RE: Commons at Dry Creek Planned Unit Development (PUD) PD-16-00001 and Preliminary Plat (LP-17-00004) – Response to submittal items and request for additional information

RE: PUD PD-16-00001
Preliminary Plat LP-17-00004
MDJ Response (received 05-29-2019)

TO: Community Development Services
FROM: Taylor Gustafson, Environmental/Transportation Planner TG
DATE: May 10, 2019
SUBJECT: Public Works review of Prelim Long Plat LP-17-00004 (Commons at Dry Creek)
Note: Also referenced as Planned Unit Development PD-16-0001

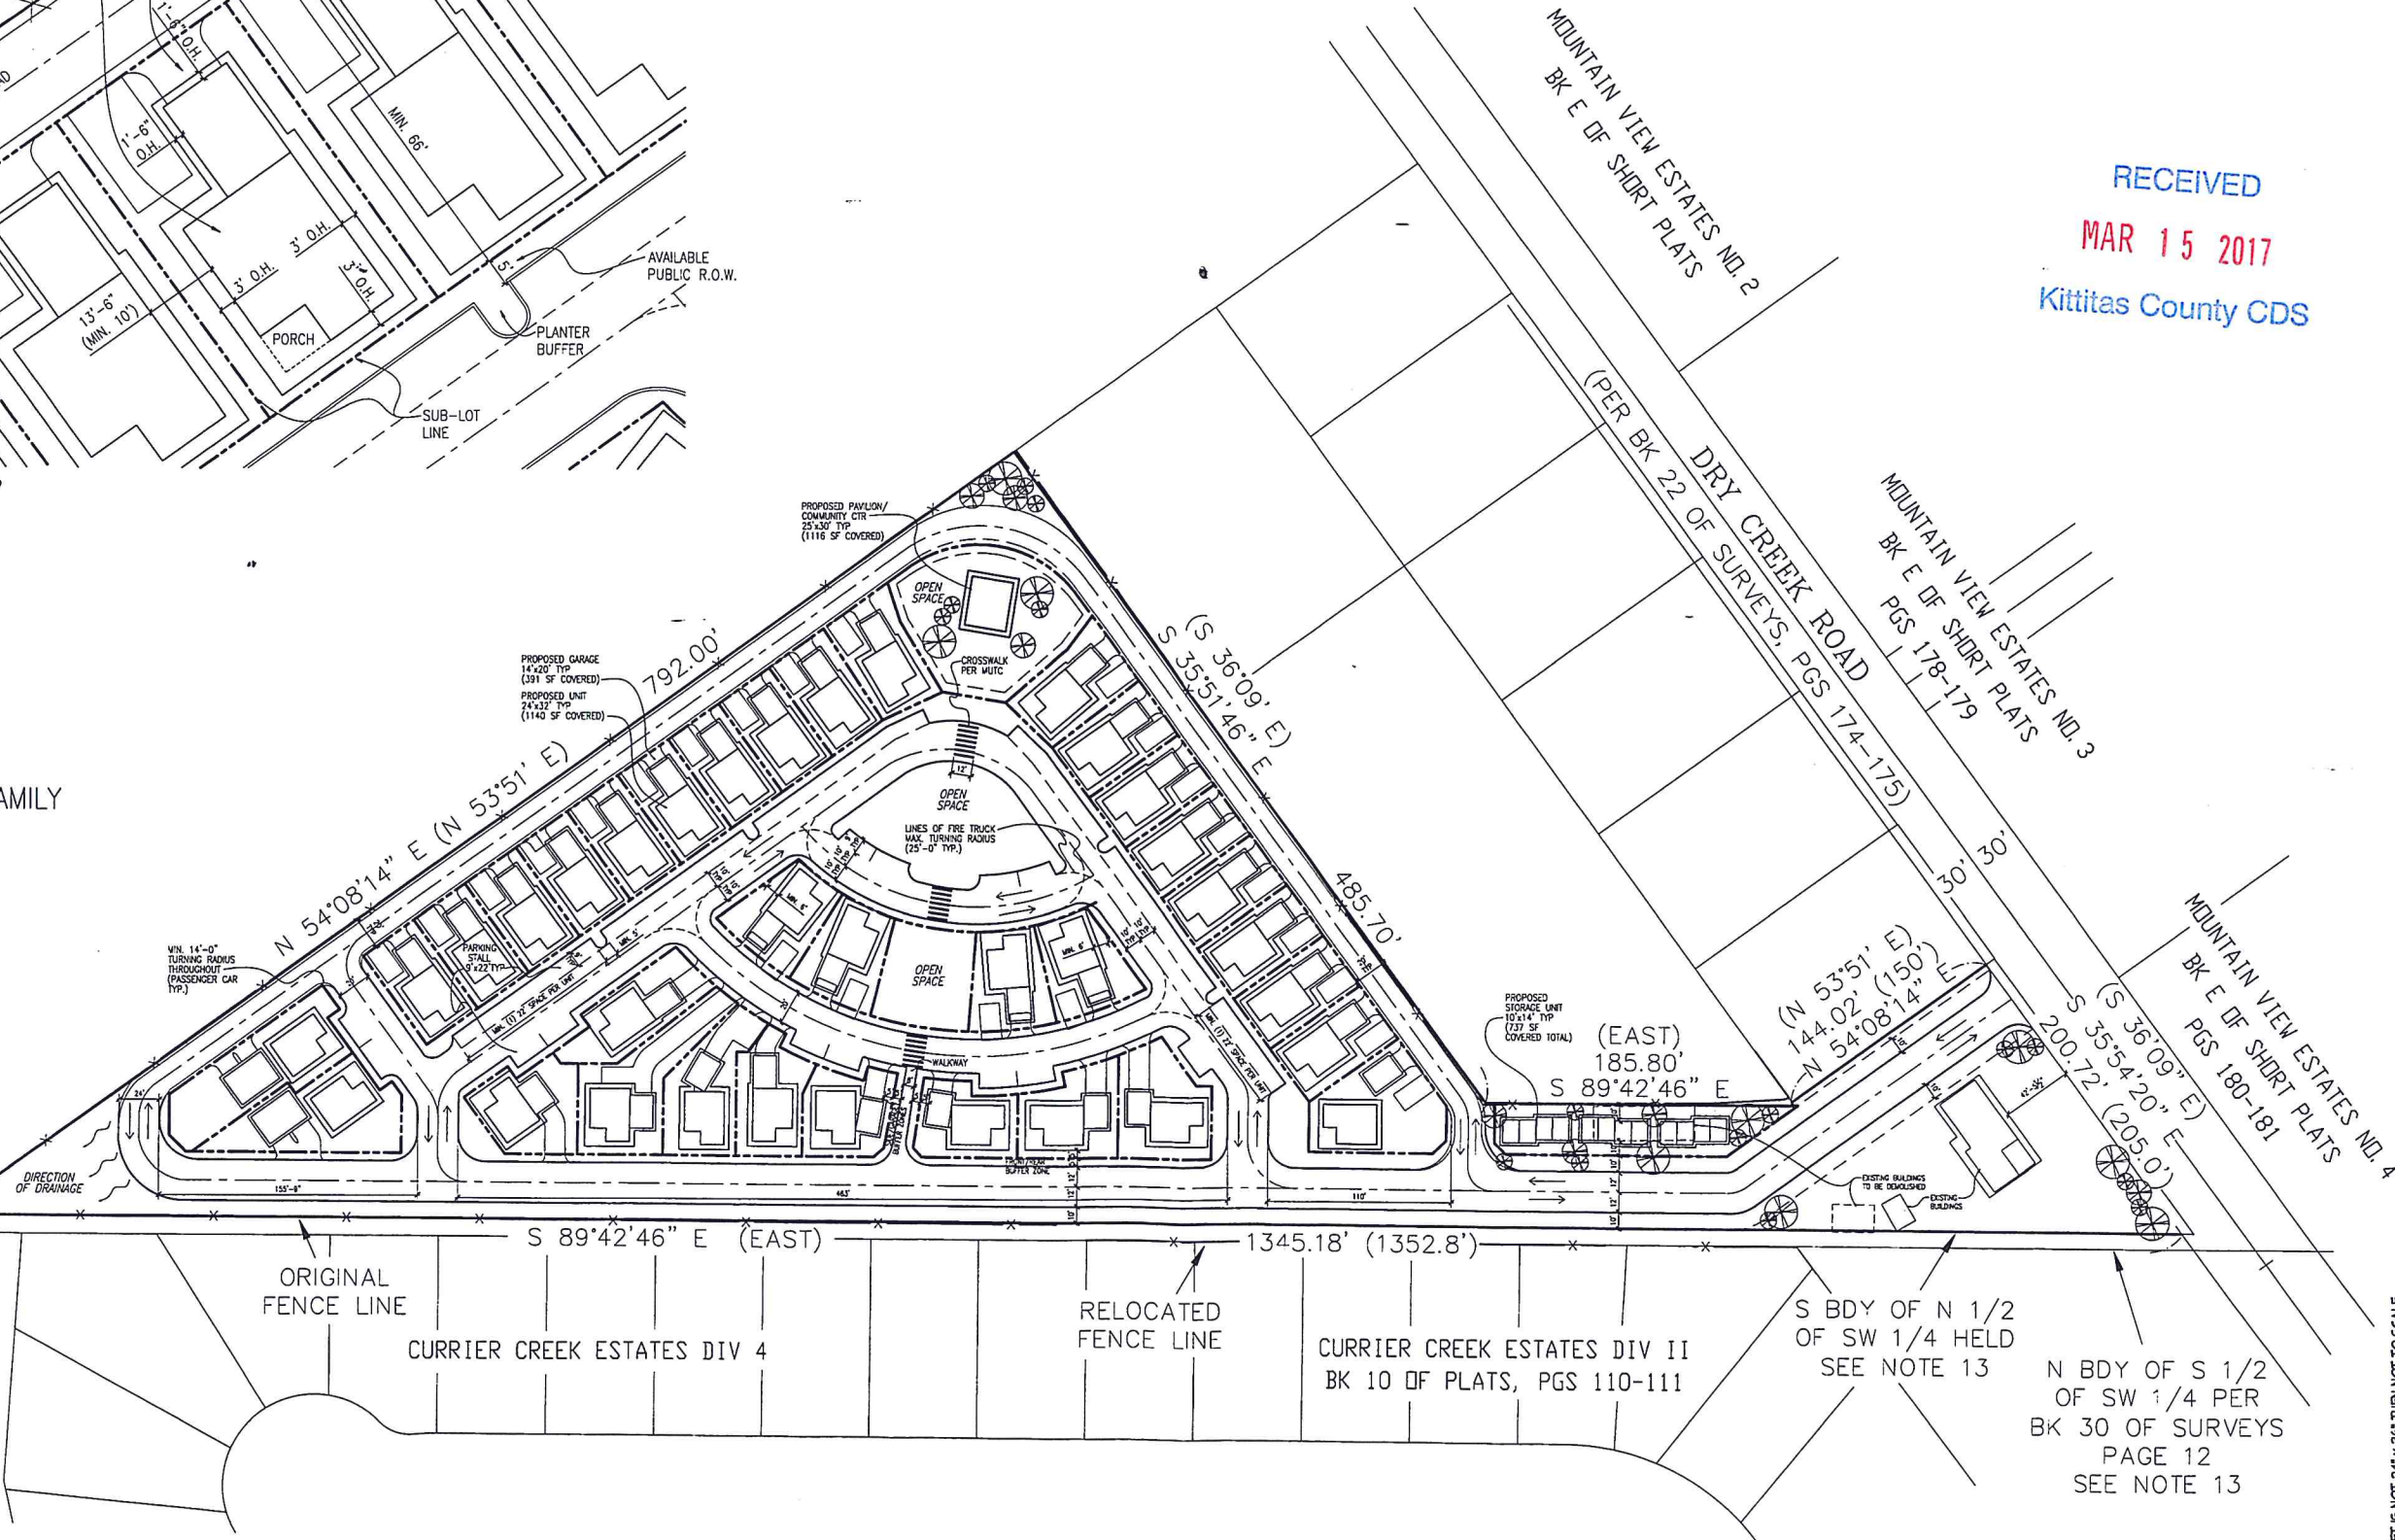
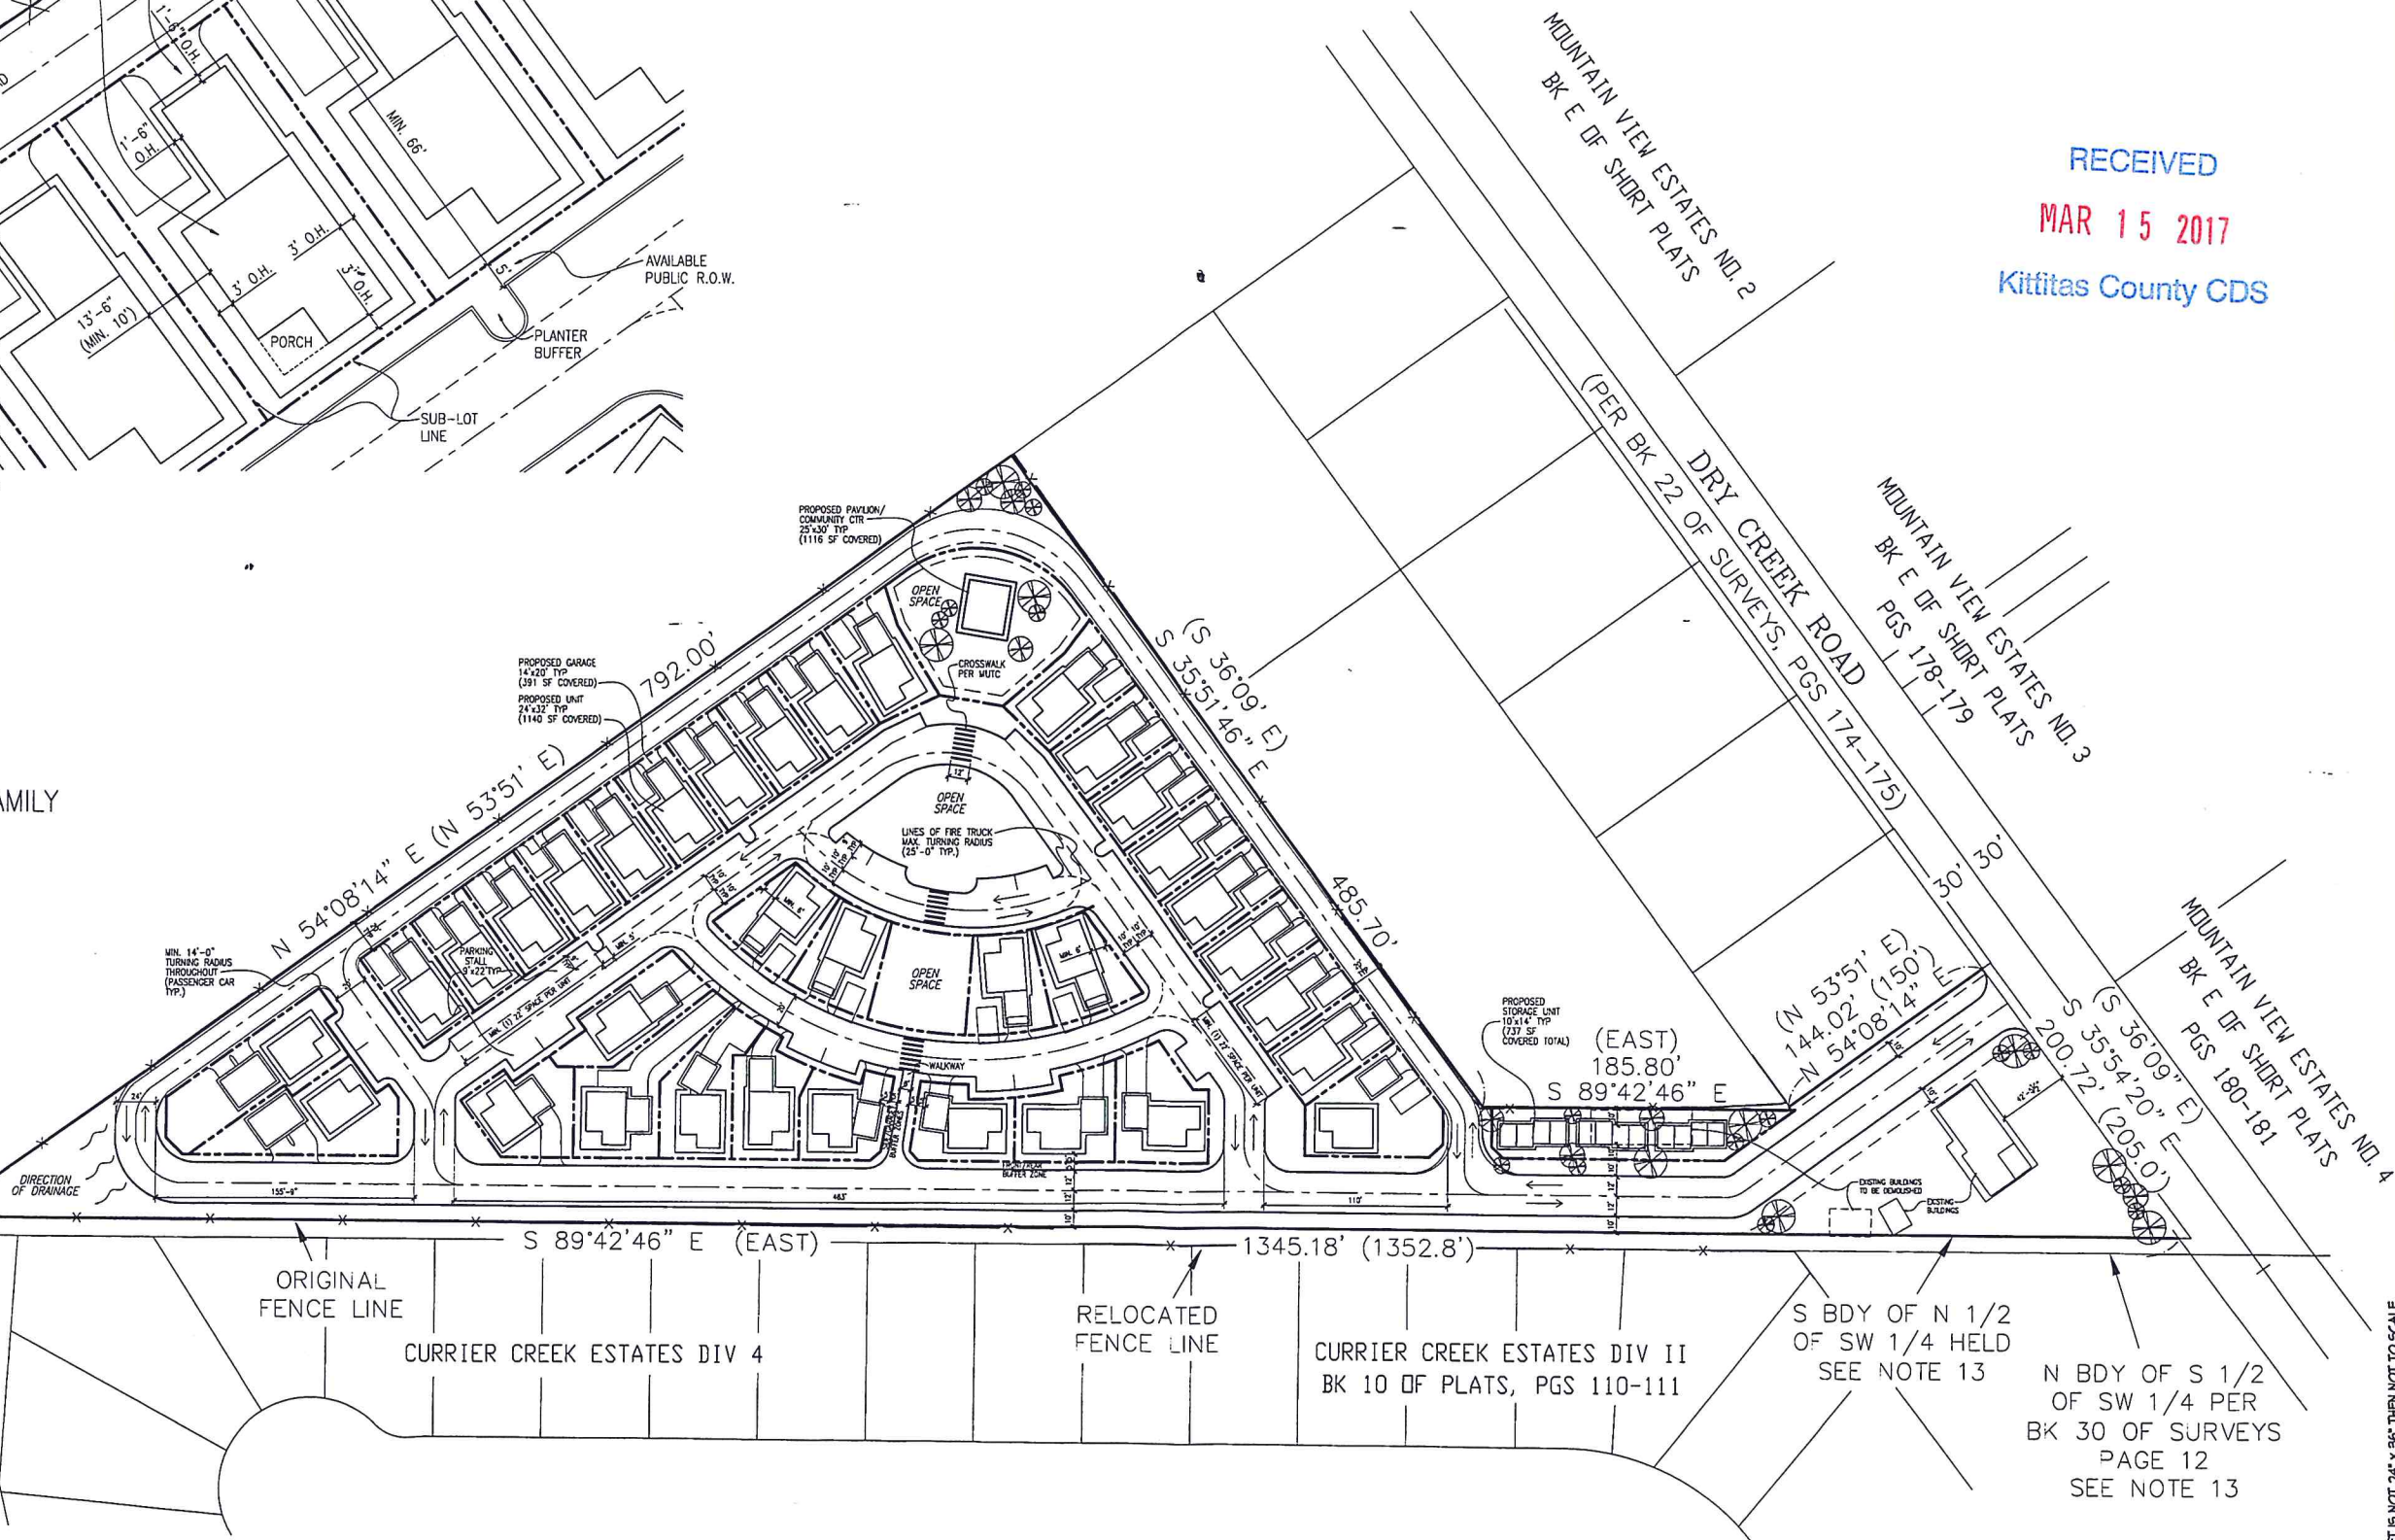
Sheet 2 of preliminary plat:

- g. BSBL is not included in the Legend.
- h. The easement through the adjacent parcel will need to be created via a separate document and referenced on the face of the Final Plat.

7. BSBL is not included in the Legend.

8. The easement through the adjacent parcel will need to be created via a separate document and referenced on the face of the Final Plat. The adjacent parcel is zoned Urban residential, with a side yard setback of 15 feet to boundaries or easements. This appears to fall quite close to the existing building, and as such, the distance between building and easement line should be noted.
